**KIRKLEES METROPOLITAN COUNCIL
INVESTMENT & REGENERATION SERVICE**

**DELEGATED DECISION TO DETERMINE APPLICATIONS FOR
CONSENT, AGREEMENT OR APPROVAL REQUIRED BY CONDITION**

Reference No:	2021/44/92565/W
Site Address:	345, Bradley Road, Bradley, Huddersfield, HD2 1PR
Description:	Discharge of condition 7 (Fences/Boundary) on previous permission 2019/91083 for the demolition of existing dwelling and erection of detached dwelling with detached garage/store
Recommending Officer:	Sam Jackman

2021/92565 – Officer Report

PROPOSED SIDE FENCE DETAIL A-A Scale 1 : 50

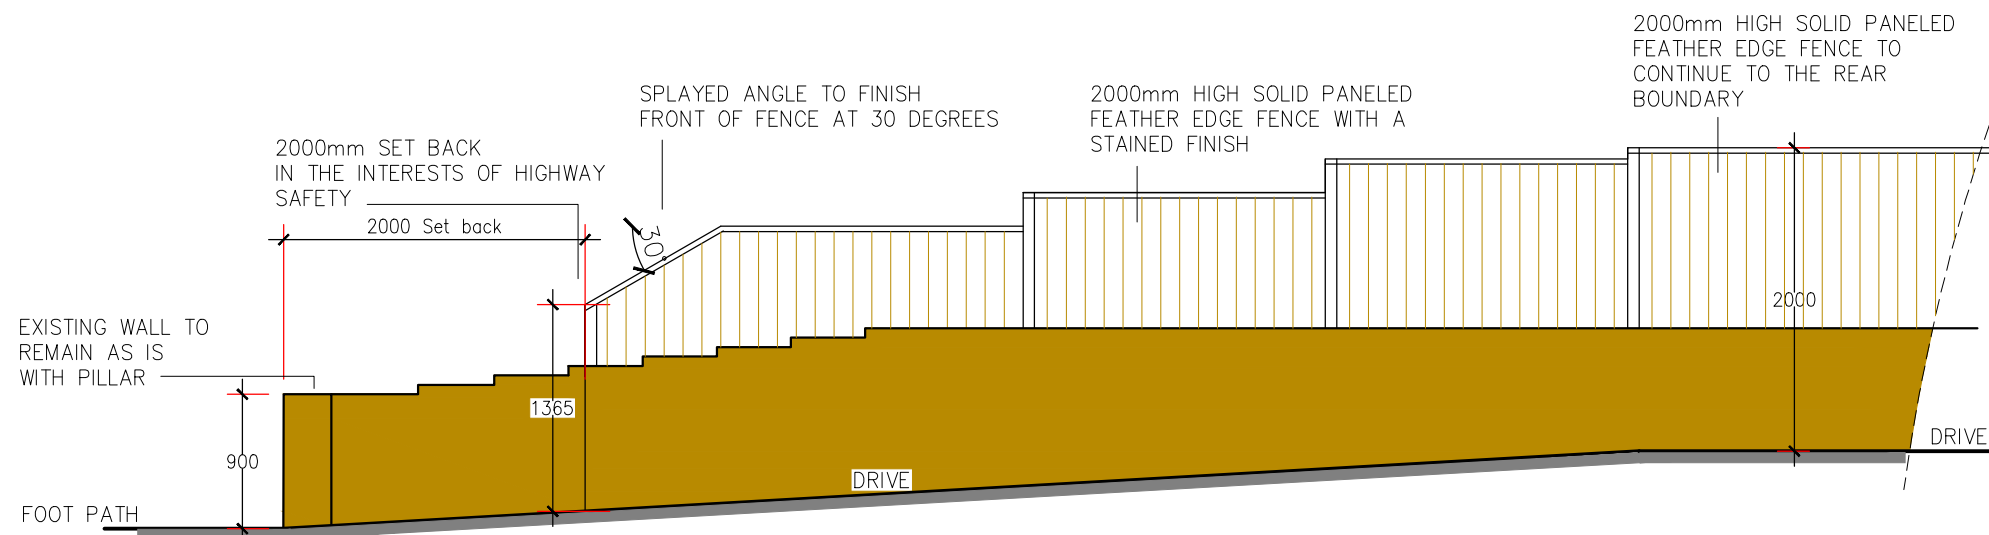
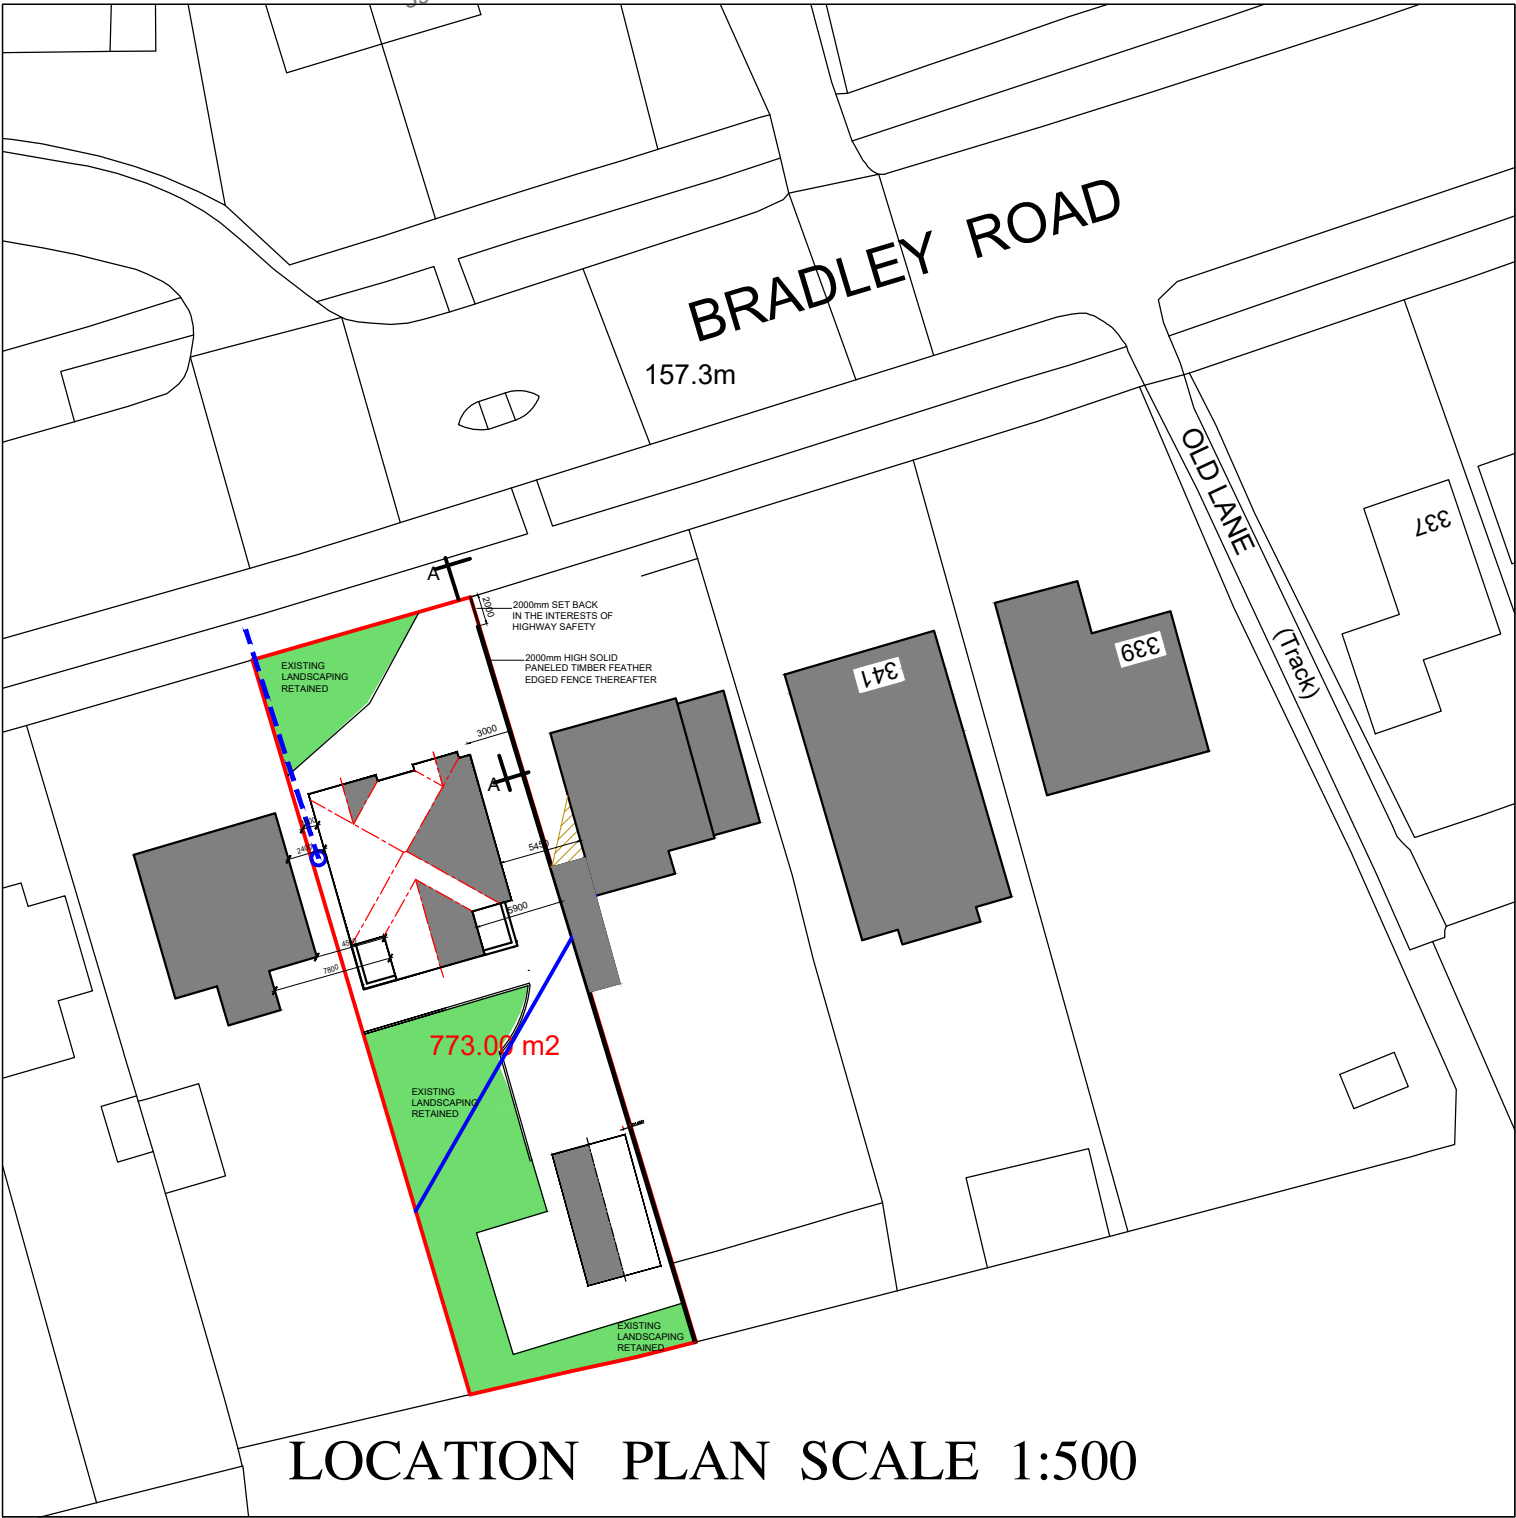
Although the general fencing as initially proposed was considered acceptable, and would retain the privacy of residents of adjoining properties, there was concern that the height of the fence close to the boundary with Bradley Road could hinder visibility for drivers leaving both nos. 343 and 345. The applicant was approached to provide clarification on this point.

The fence has been amended so that the existing wall remains at 0.9m for the first 2m, the fence starts at 1.35 which is splayed for the first 0.9m before being raised to 2m.

The boundary treatment at the rear where the existing garage will be removed will be replaced with conifers for the first 4m with the next 6m of conifers being retained. Along the boundary where the new garage will be, the boundary is shown to replace 4.5m of the existing hedge with a timber 2m high fence.

Following the receipt of amended details the fence details as outlined on plan number PDA17-167-005 Rev C received 14.2.22 are considered acceptable to discharge condition 7 of application 2019/91083.
